**Our Ref: P/55/12/
Your Ref:**

Application for Planning Permission for Works or Extension to a Dwelling

Development Front in-fill extension between garage & lounge & alterations to roofline over garage & new extension. Conversion of garage to habitable space & replacement of rear conservatory with extension under Permitted Development

Location 9 Durham Close Bognor Regis

Existing GF Plan

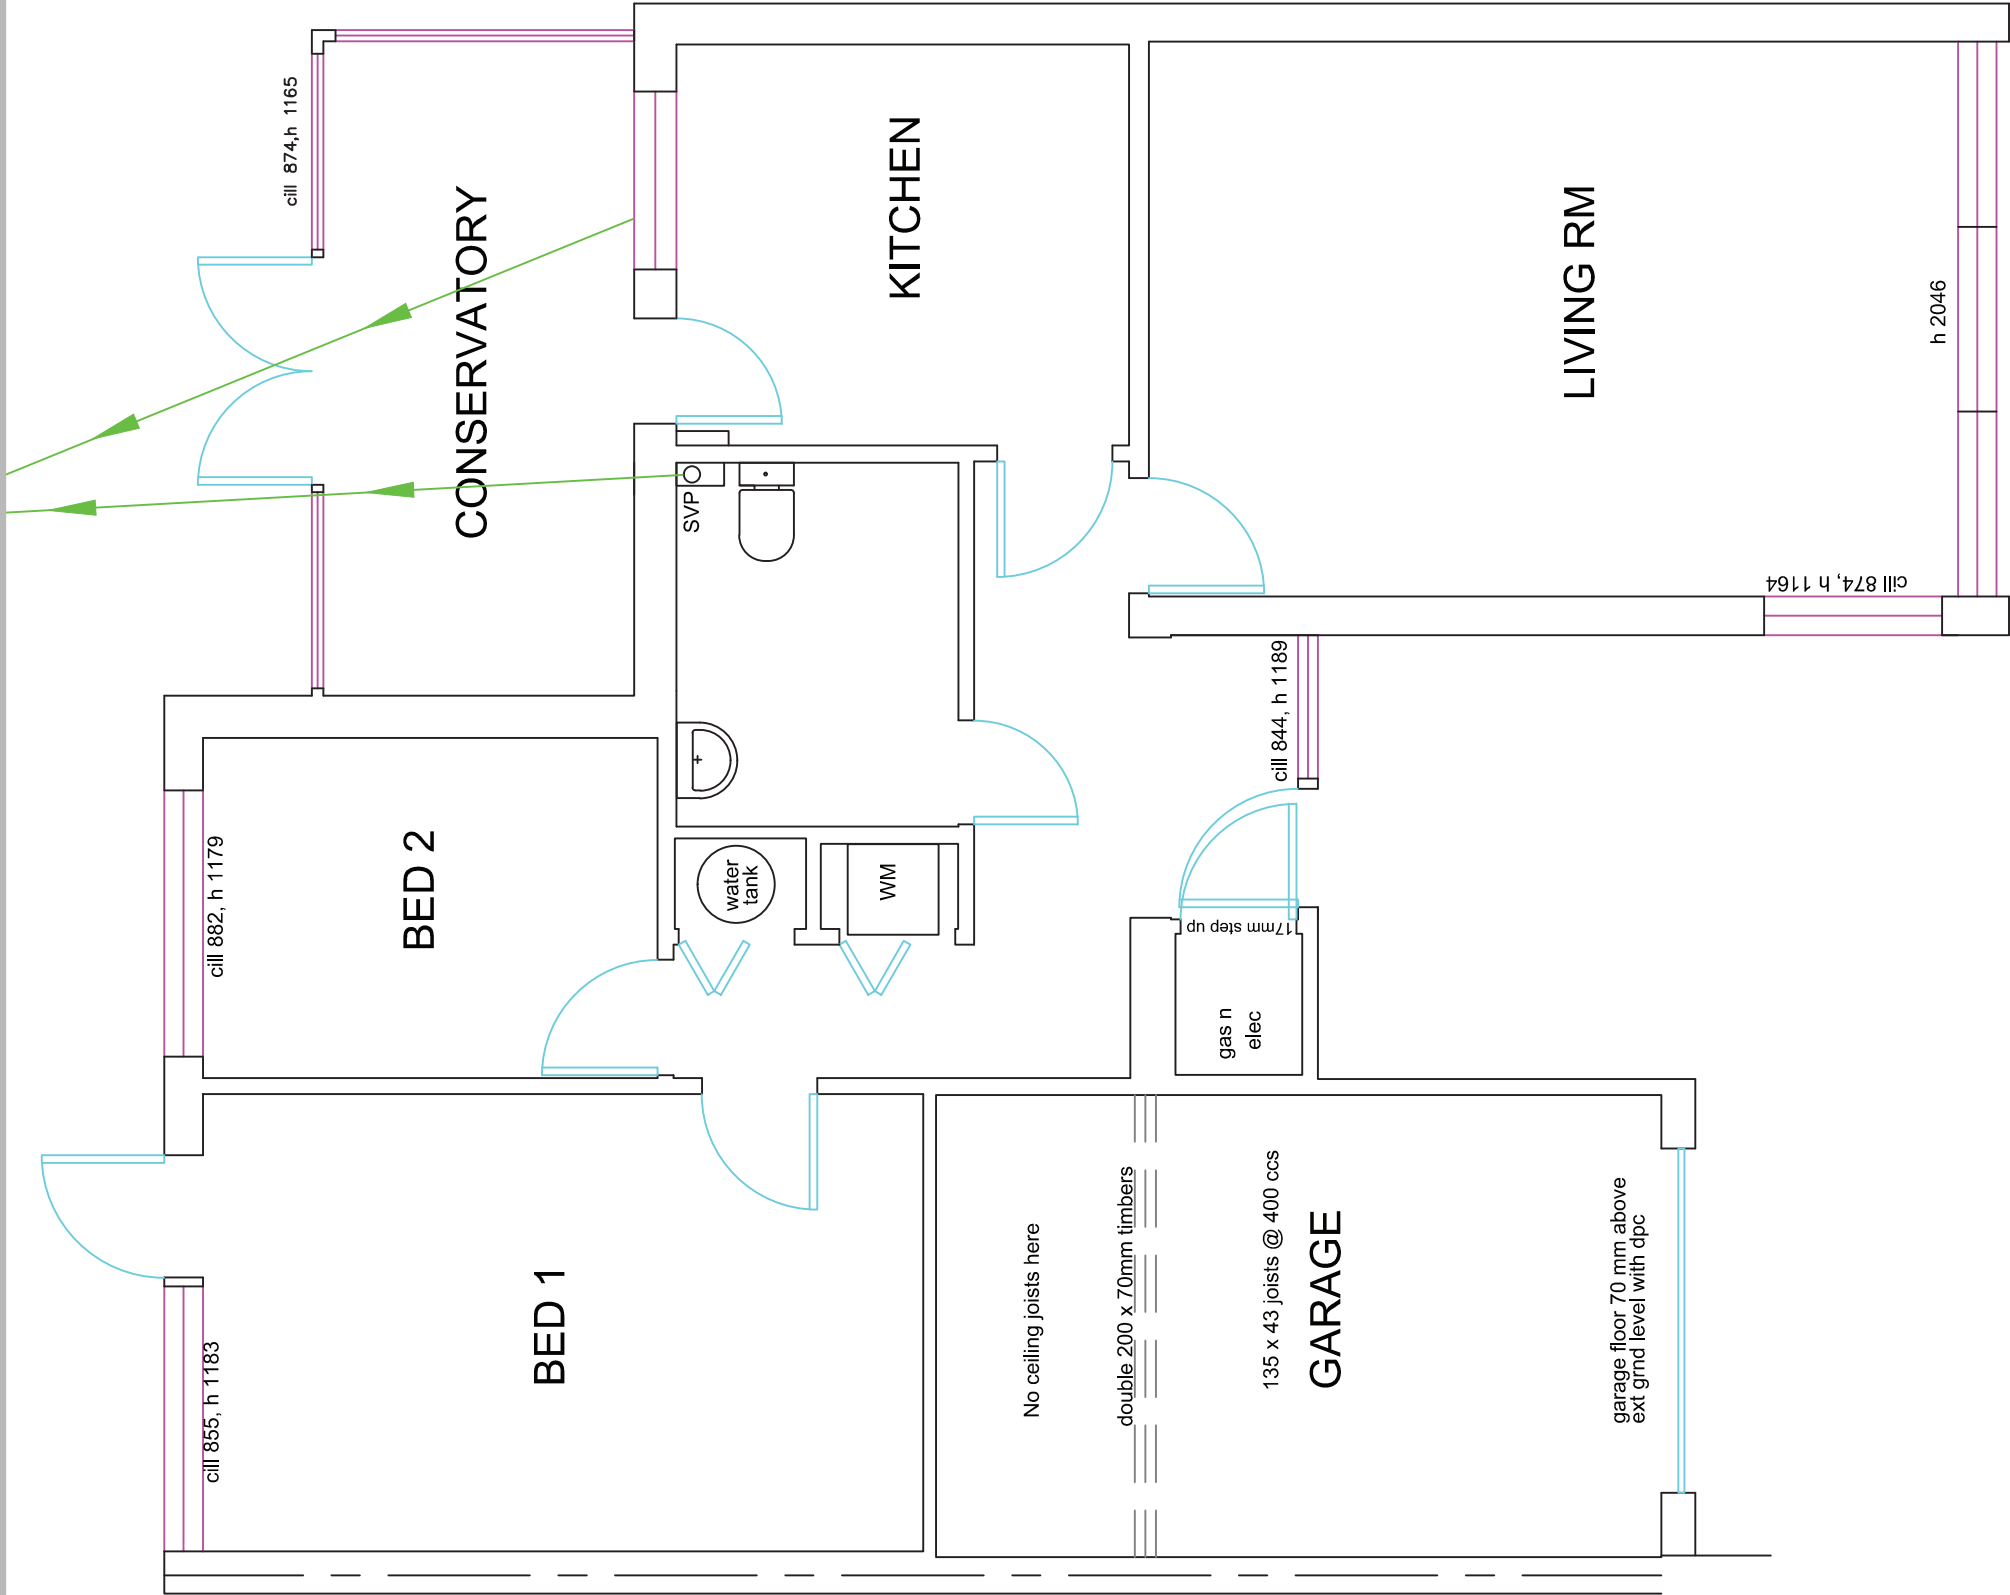
Please provide 1 electronic or 3 paper copies of a revised existing floor plan to show the garage door.
